Our ref: ESR Horsley Logistics Park-Mod-7 (SSD-10436-Mod-7)

Subject: Request for Additional Information

I refer to the ESR Horsley Logistics Park-Mod-7 (SSD-10436-Mod-7) Modification Application. After careful consideration, the department is requesting that you provide additional information.

1 Estate Masterplan

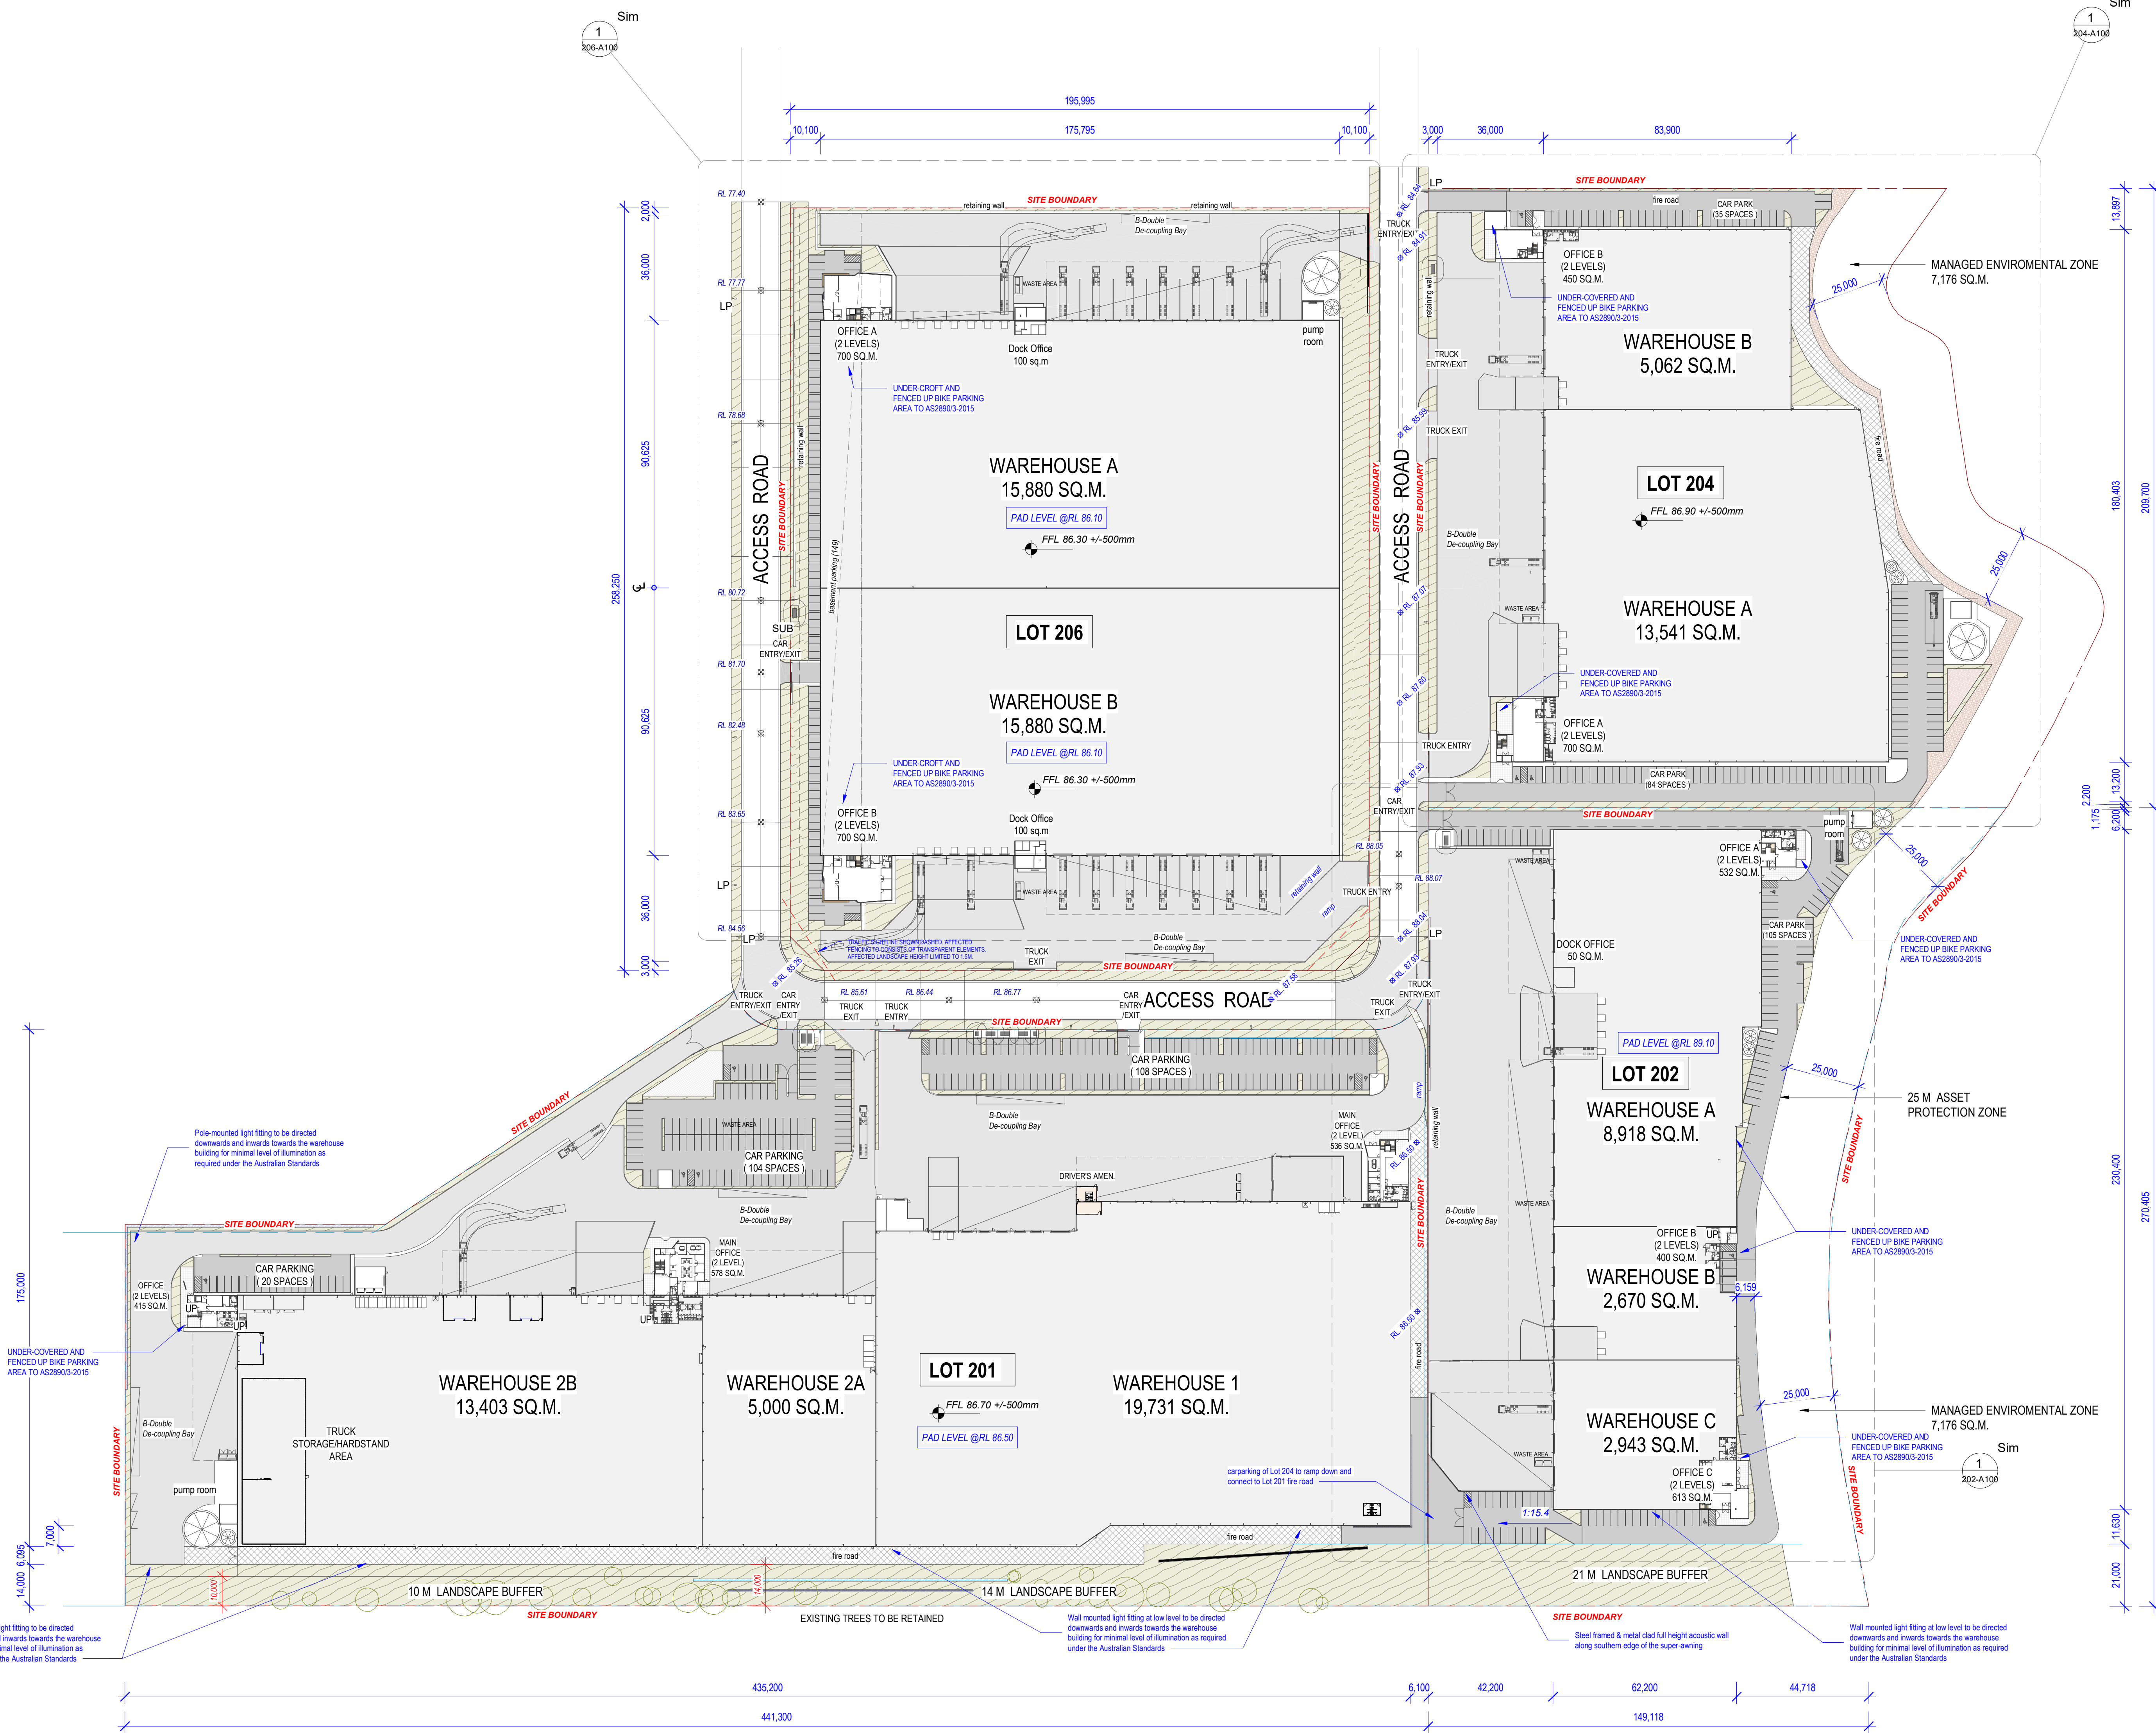
- the written consent of the landowner
- the total building area figure (109,765 m²) within the proposed Estate Masterplan (version P15) is inconsistent with the total building area figure (109,815 m²) in the Estate Masterplan (version P15) within the consent. As no change to the Gross Floor Area (GFA) is proposed and to ensure consistency with the consent, the Department requires the total building area figure within the proposed Estate Masterplan to be updated. The Department also requires that the version number of the Estate Masterplan is also updated
